Subject: Prosperity Feeder 11

Hope all is well with you. PNM is planning to construct electric distribution feeders during the first quarter of 2024 that will connect the planned Prosperity Substation (to be located on the south side of Los Picaros Road SE just east of the existing Prosperity Solar/Energy Storage Center) with other existing electric infrastructure in the area. One of the distribution feeders, Feeder 11, is being planned to connect the Prosperity Substation with existing and new facilities near Sunport Boulevard and will be located along University Boulevard south of the Rental Car Center (see the attached PDFs for the structure locations for Prosperity Feeder 11).

Prosperity Feeder 11

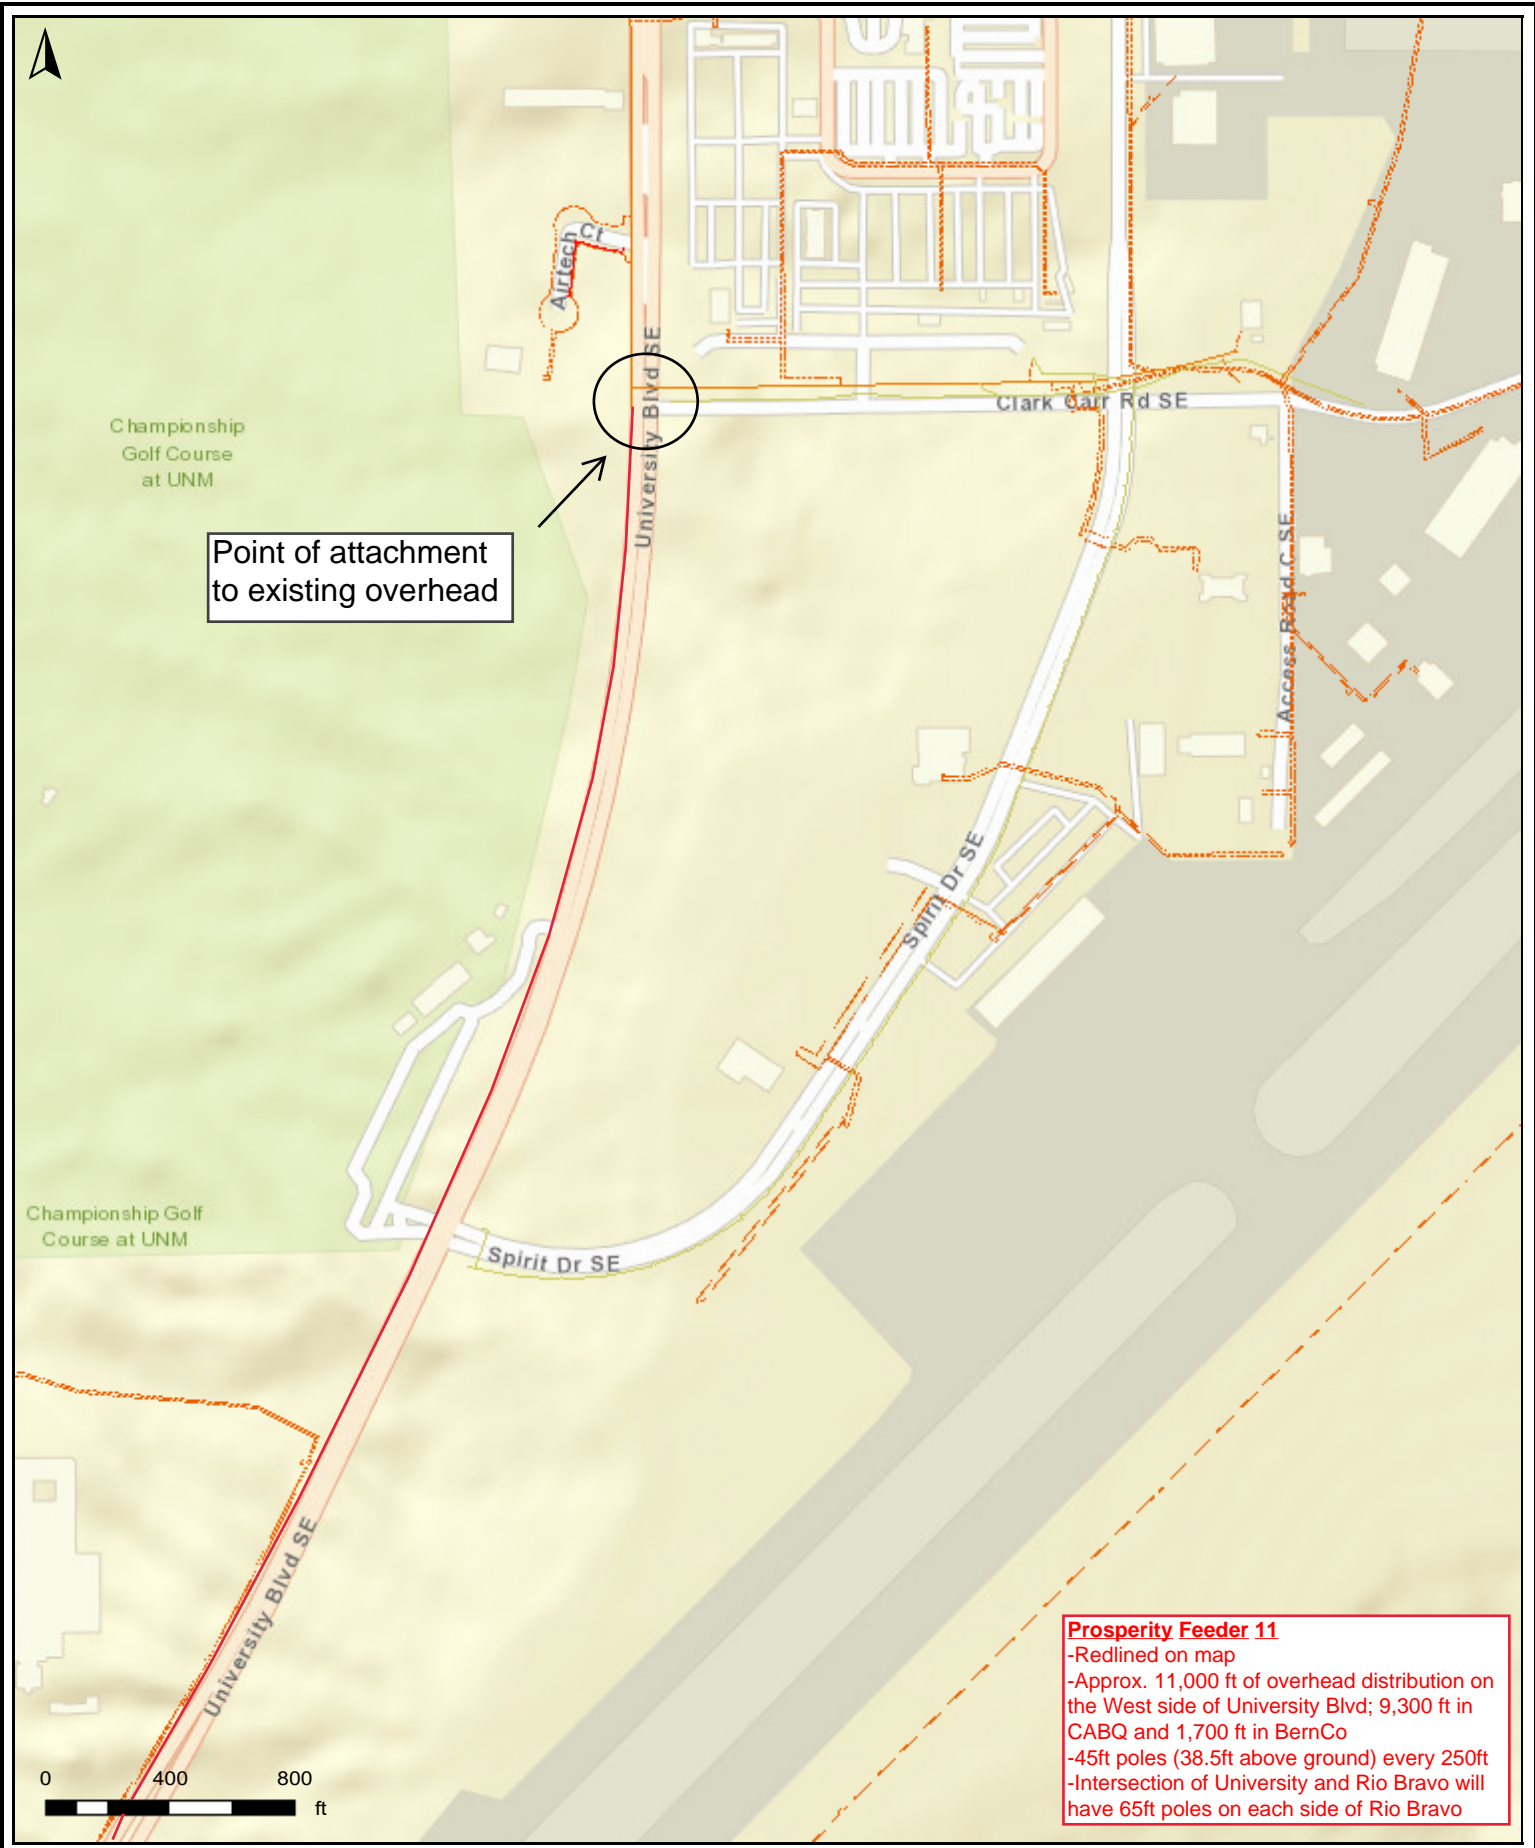
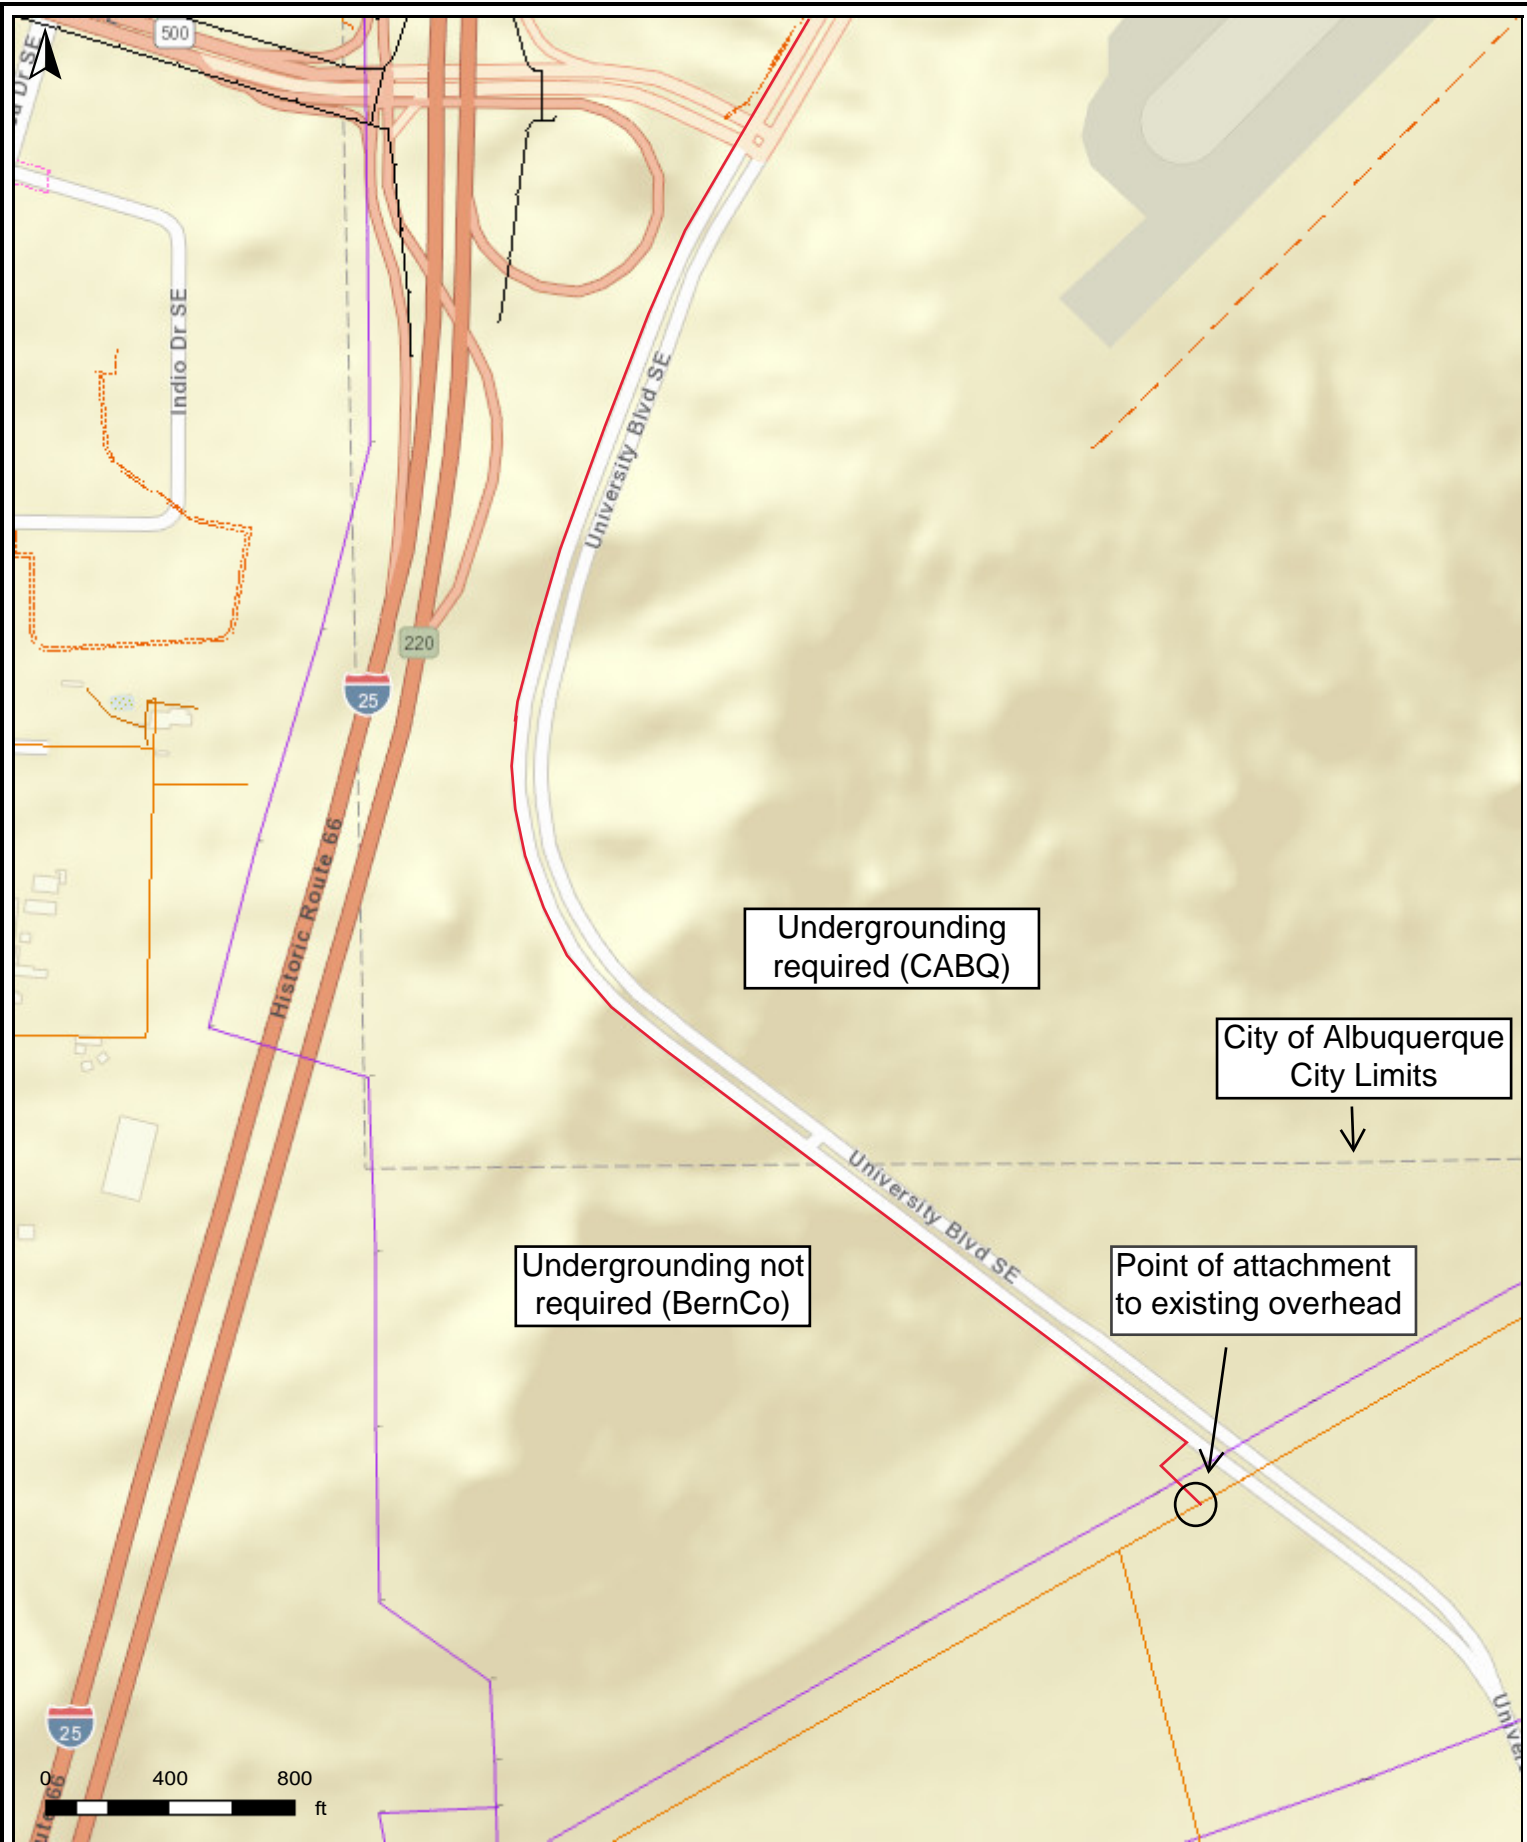
In regards to your proposed line, as long as the top of the poles are below the grade of the mesa that Runway 3/21 is sitting on, we should be fine.

You will still need to submit a 7460 to FAA, but that should not be a major item if we are below the grade of the Runway. As to the master plan files, we can reach out to our consultant that oversees that and see if we can get you those files. Thanks
